**United Utilities Water PLC
Developer Services & Planning**
Thirlmere House
Lingley Mere Business Park
Lingley Green Avenue
Great Sankey
Warrington WA5 3LP

Your ref: 3/2013/0229
Our ref: DC/13/1776
Date: 07-MAY-13

Location: Brown Leaves Hotel, Longsight Road, Copster Green
Proposal: Discharge of conditions

**ROAD AND MAIN
DRAINAGE LAYOUT**

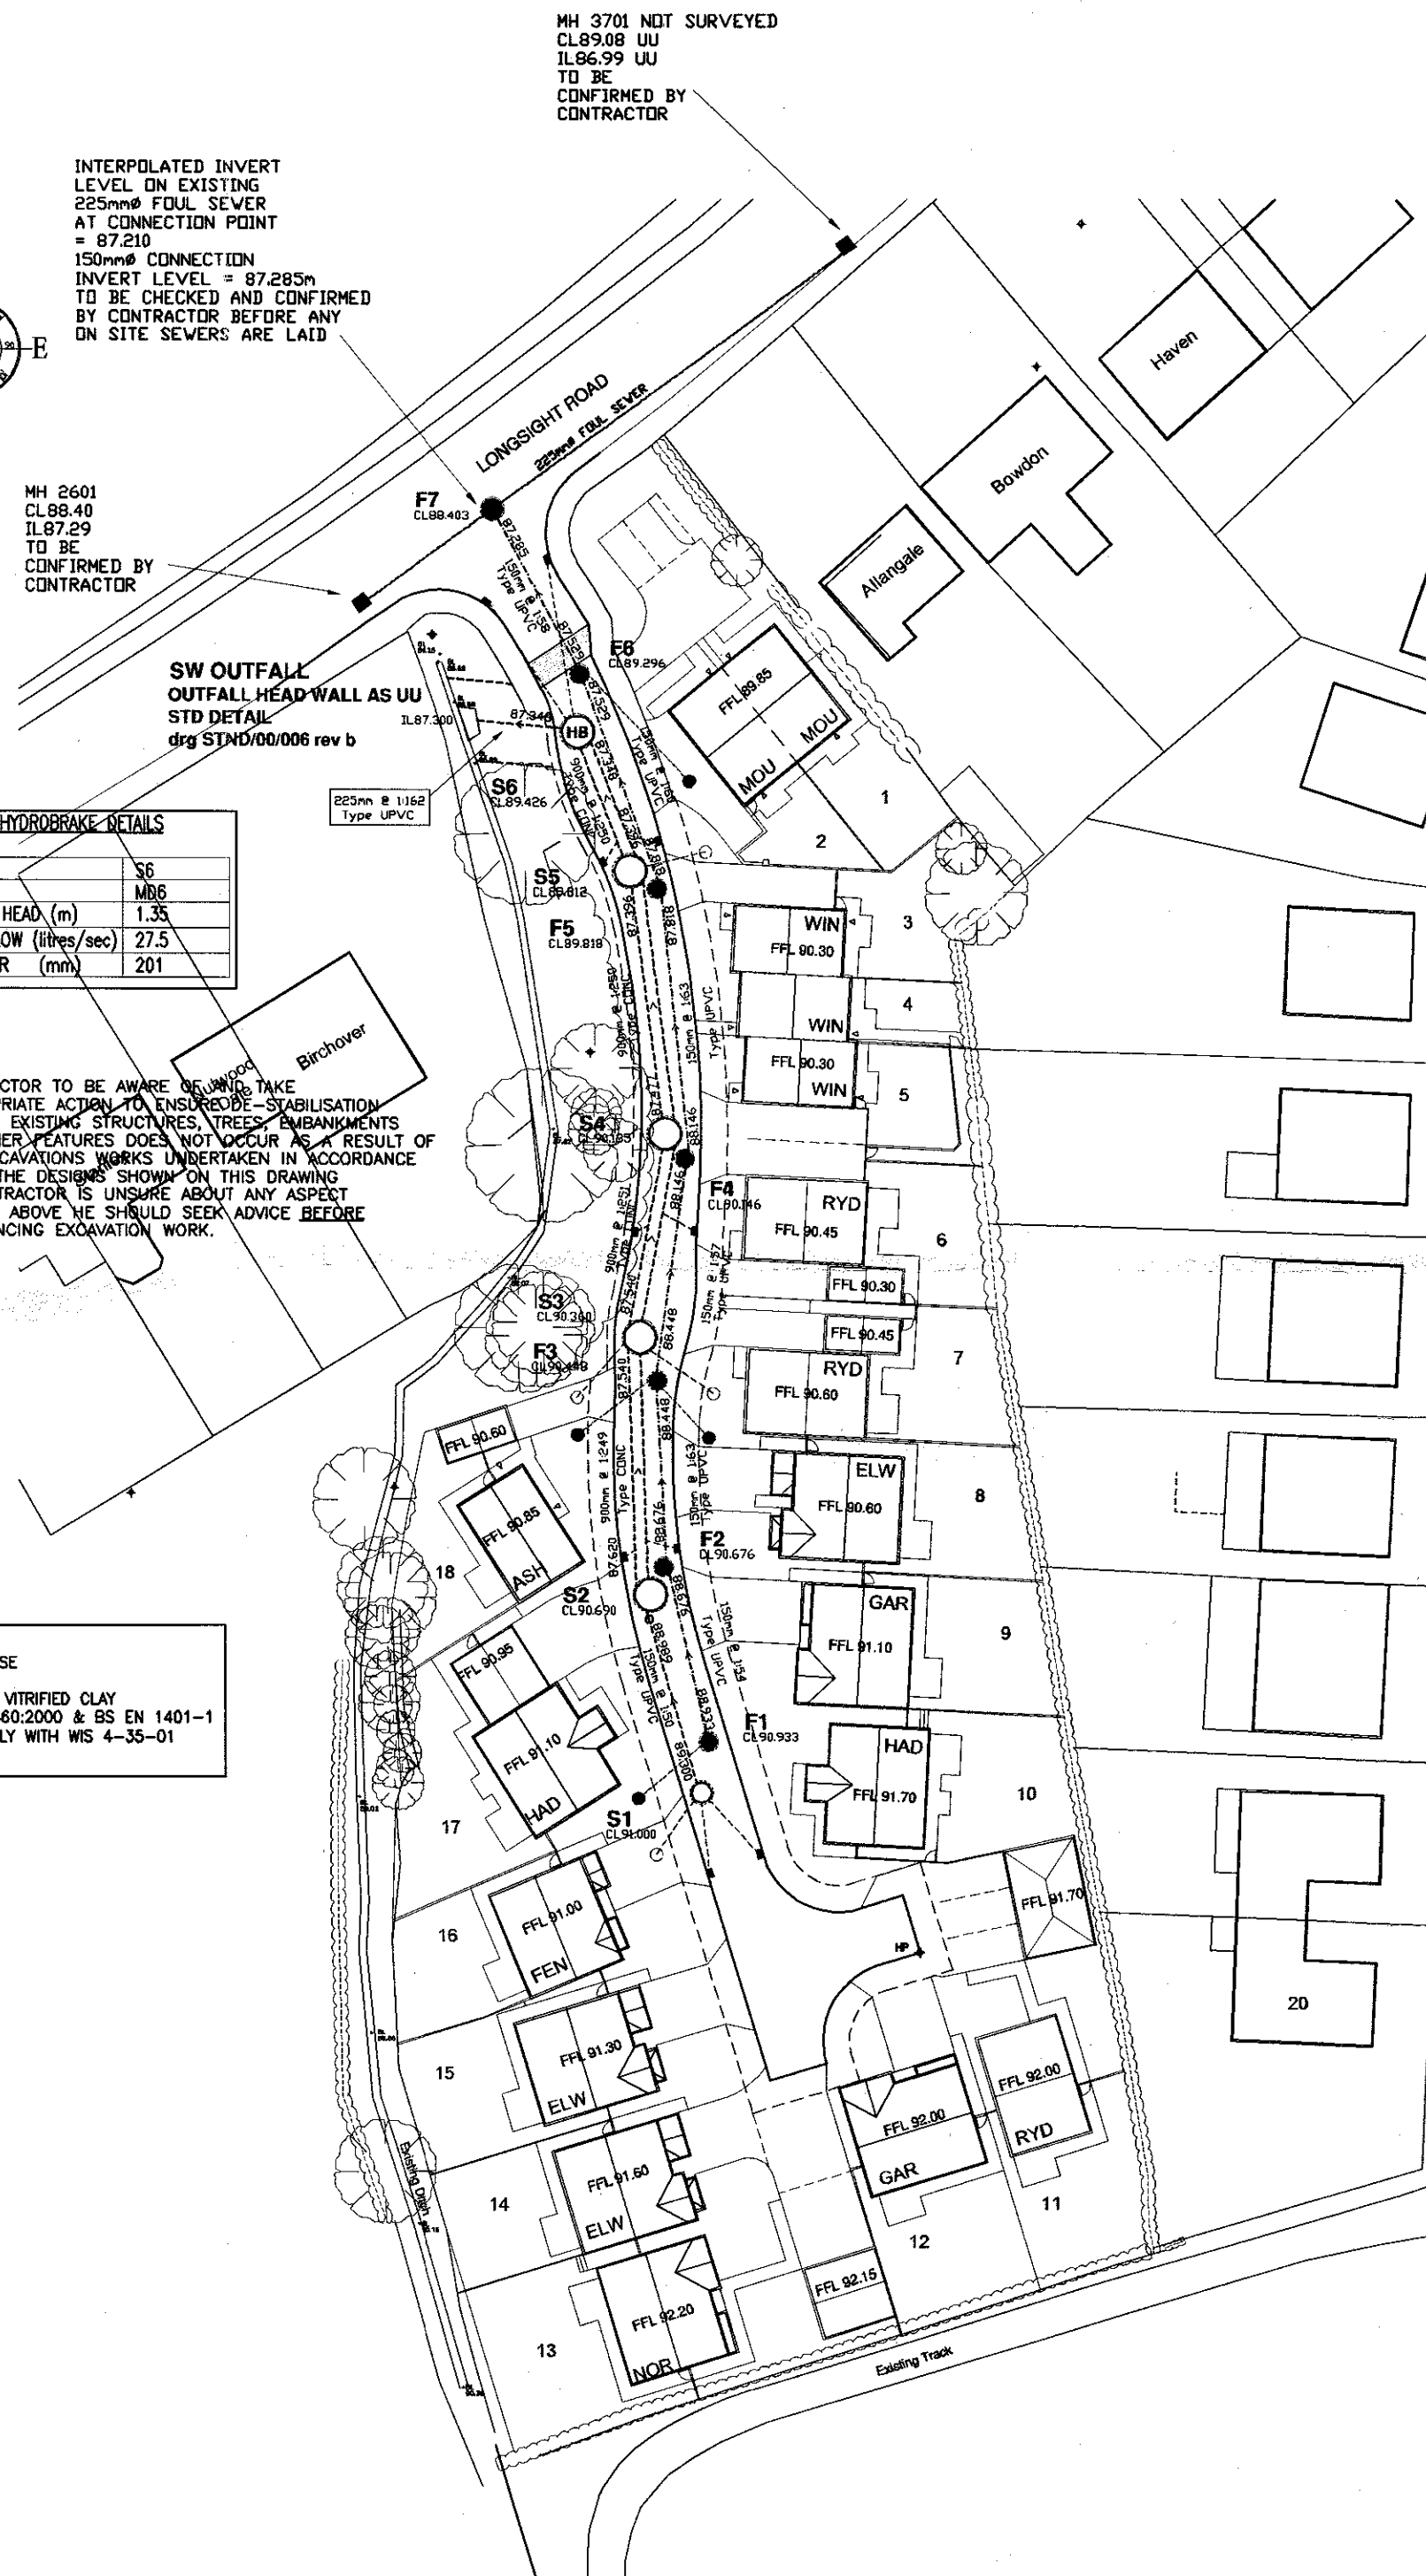
The developer does not appear to have submitted any drainage plans or site investigations showing the most sustainable method of drainage therefore I am unable to discharge conditions 10 or 11.
